Our ref: HA/2019/121164/01-L01
Your ref: FP/249/18/PL
Date: 13 March 2019

REPLACEMENT OF EXISTING BUNGALOW WITH 1 NO. CHALET BUNGALOW (TO APPROVED DESIGN FP/259/17/HH).

22 NORTH WAY, FELPHAM, PO22 7BT

DRAWING
PROPOSED PLANS
DRAWING No
236/04A
REVISION
SCALE 1:100
DATE SEPT 2017
DRAWN LA
CHECKED

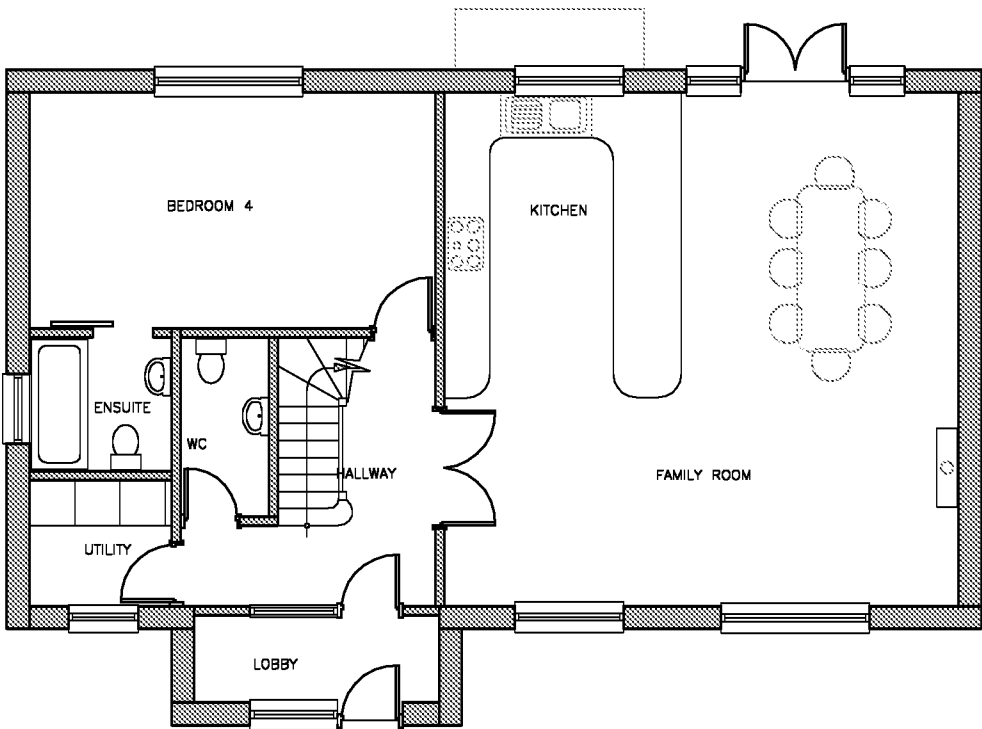
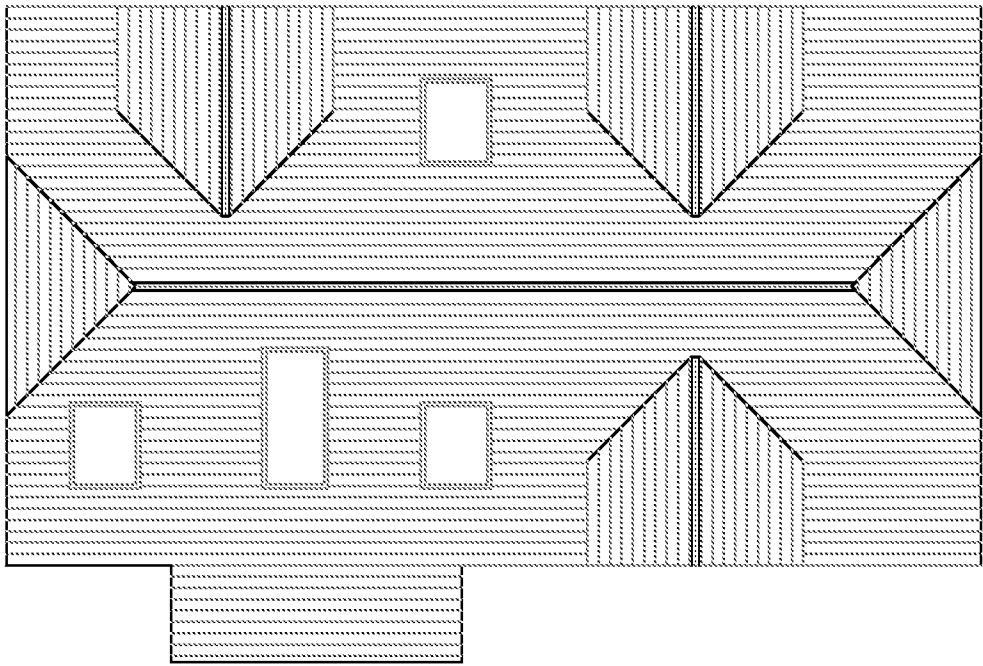
The development shall be carried out in accordance with the submitted flood risk assessment (ref. FP/249/18/PL Dated Nov 2018, previously approved FP/259/17/HH) and the following mitigation measures it details:

- **Finished floor levels shall be set no lower than 2.66 m above Ordnance Datum (AOD)**
